TO	Nicole Brewer, Director, Energy Assessments
FROM	Mark Davey
DATE	17 July 2026
OUR REFERENCE	0617753
SUBJECT	Keri Keri Wind Farm (SSD-3858962) Request for Additional Information

Keri Keri Wind Farm (SSD-3858962)–Request for Additional Information

Ref No	Theme	Submission	Response	Where Addressed
TfNSW-01	Traffic (generation)	1. Preconstruction Minor Works for workers accommodation camp traffic assessment requirements. A complete assessment of the wind farms and workers' accommodation camp construction pre-construction minor works is required and is to include: - Assessment of traffic volumes and identification of the types of vehicles that will be used during this period, including the largest design vehicle. - Perform a swept path analysis for the largest heavy vehicle at the existing intersection, ensuring it can navigate within the current pavement. If the design vehicle cannot turn easily, implement necessary mitigation or temporary works. - Assess existing Safe Intersection Sight Distance (SISD) and propose measures to achieve compliance, - Identify AM/PM peak hour traffic volumes and proposed volumes during this time. Traffic volumes during the AM/PM peak hours are to be c

Typical Cross Section - Culvert Extension

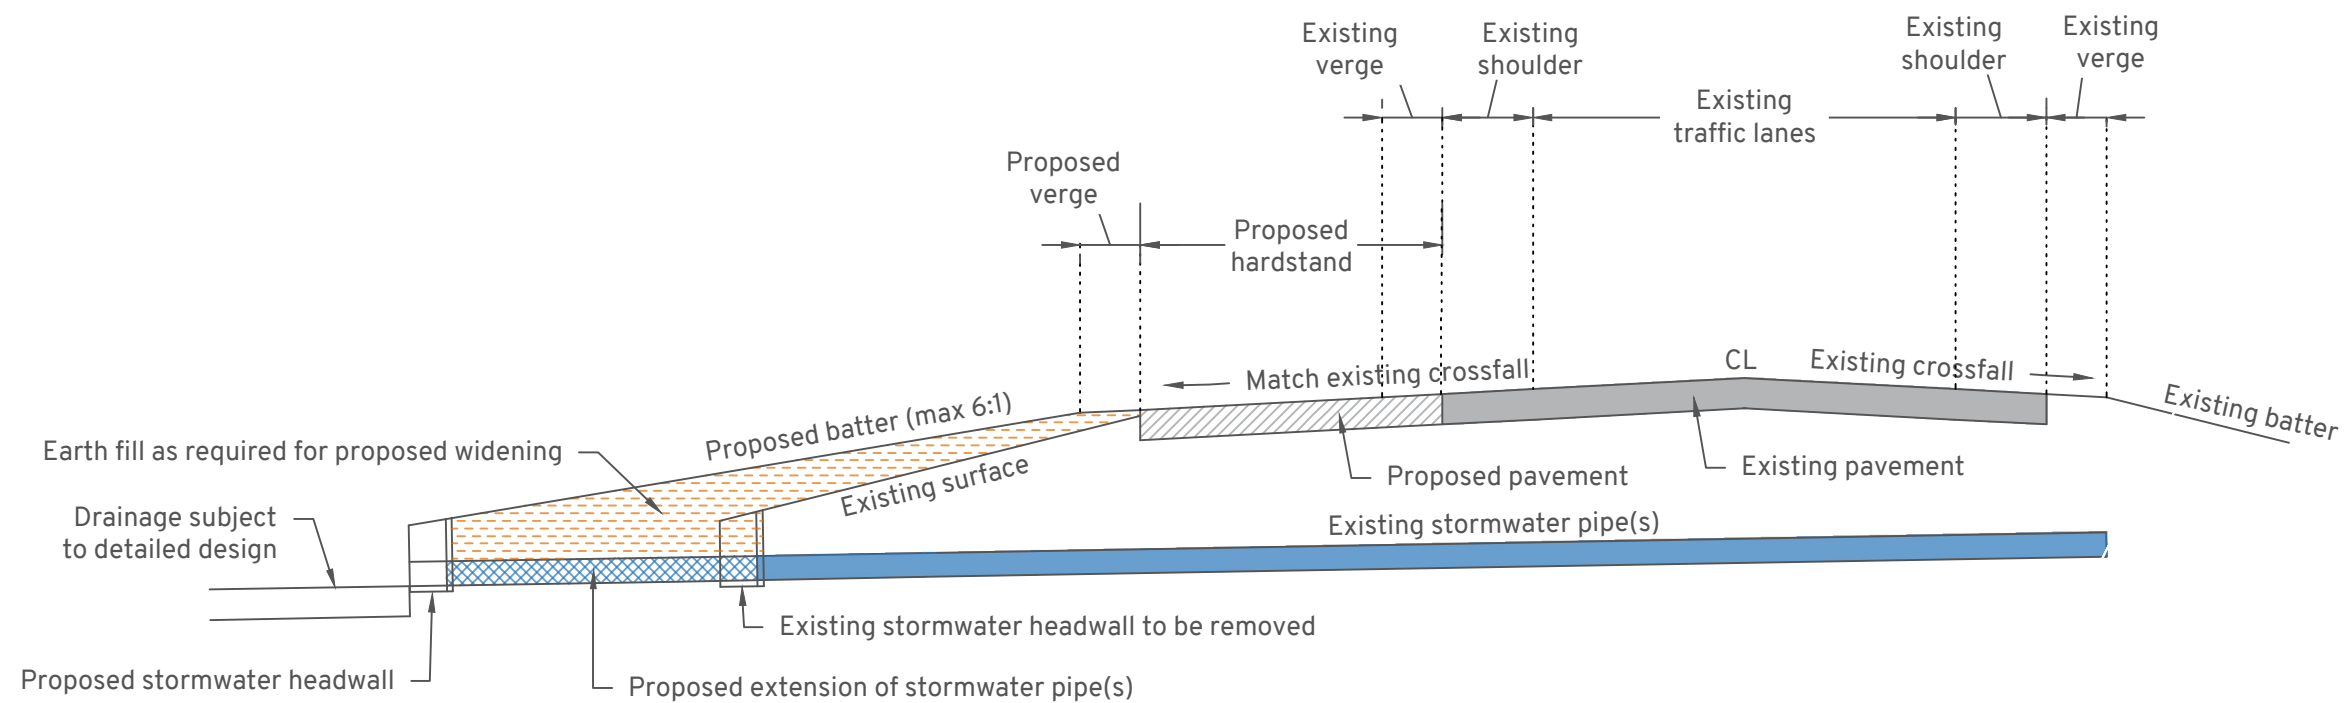
TfNSW-03	Strategic Designs	a. Revision D Civil Design, RJ Andrews SPA - Murray Valley Hwy onto Sturt Highway - The existing fill embankment is high, with swept paths showing to track close to cadastre boundaries. Hardstand areas will need to be quantified to determine the scope and footprint of the fill required for the embankment and to confirm whether land acquisition is required. b. Revision D Civil Design, RJ Andrews SPA - Murray Valley Hwy onto Sturt Highway - There appear to be numerous underground utilities located on the south-east corner of the intersection. Further investigation required to determine the level of impact.	Revised strategic concept design for this intersection is provided in Appendix A (Sheets 01-03). The vehicle swept path and hardstand areas have been adjusted to provide additional clearance to the adjacent property boundaries for embankments/batters and drainage which would be determined during detailed design. Underground utilities would also be confirmed as part of the detailed design process. Furthermore, it is understood that EnergyCo is in the planning stages for the South-West REZ and high-level strategic designs have been prepared for this intersection to accommodate OSOM movements. TfNSW is progressing the intersection upgrade through concept and detailed design stage.	Appendix A (sheets 01-03) of the Amended TIA (Attachment D)

i. Revision D Civil Design - 21012CAD003 Figure 2 - The existing fill embankment is high, with swept paths showing to track close to the cadastre boundaries. Hardstand areas will need to be modelled as part of the strategic concept designs to be revised prior to determination, to quantify the fill embankment and confirm the exact scope of the road works, and to determine whether acquisitions are required. - There appear to be numerous underground utilities located on the southeast corner of the intersection. Further investigation required to determine the level of impact.	Revised strategic concept design for this intersection is provided in Appendix A (Sheets 01-03). The vehicle swept path and hardstand areas have been adjusted to provide additional clearance to the adjacent property boundaries for embankments/batters and drainage which would be determined during detailed design. Underground utilities would also be confirmed as part of the detailed design process. Furthermore, it is understood that EnergyCo is in the planning stages for the South-West REZ and high-level strategic designs have been prepared for this intersection to accommodate OSOM movements. TfNSW is progressing the intersection upgrade through concept and detailed design stage.	Appendix A (sheets 01-03) of the Amended TIA (Attachment D)
